ELLICOTT TOWN CENTER

Filing No. 1

Construction Drawings

El Paso County, Colorado

G2

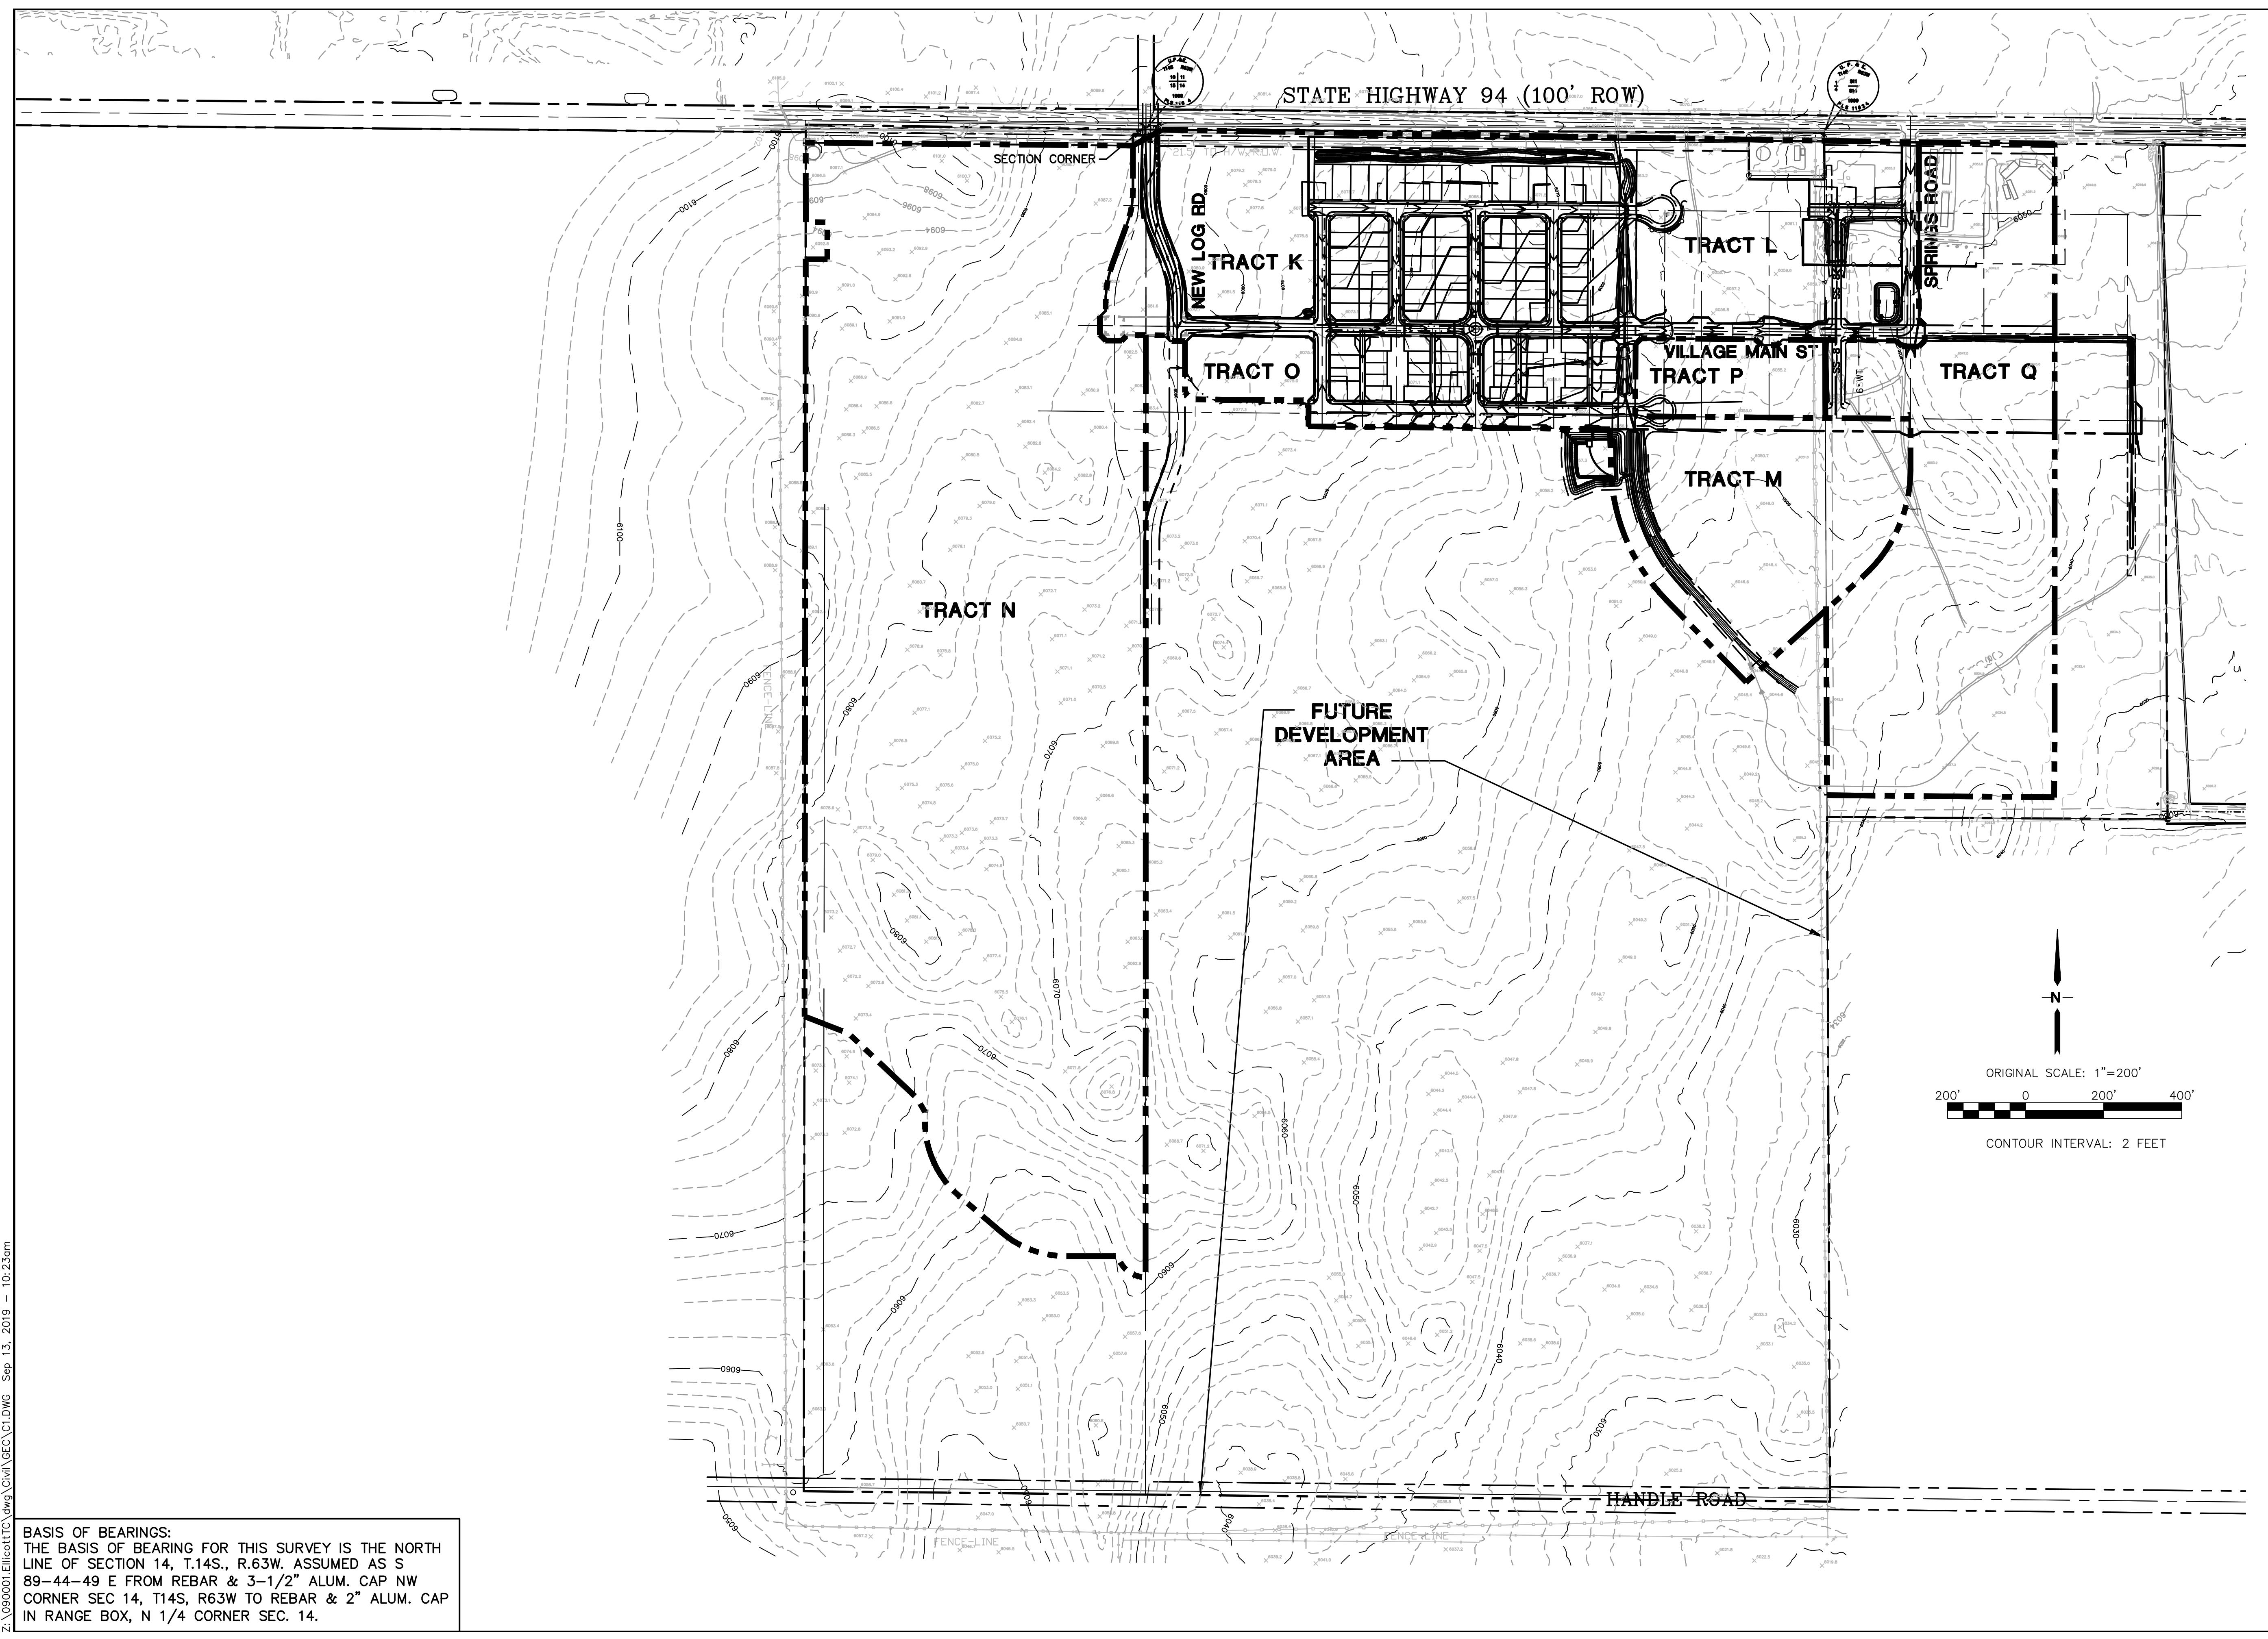
Provide list of deviations applicable to this CD set.
See comment letter.

delete
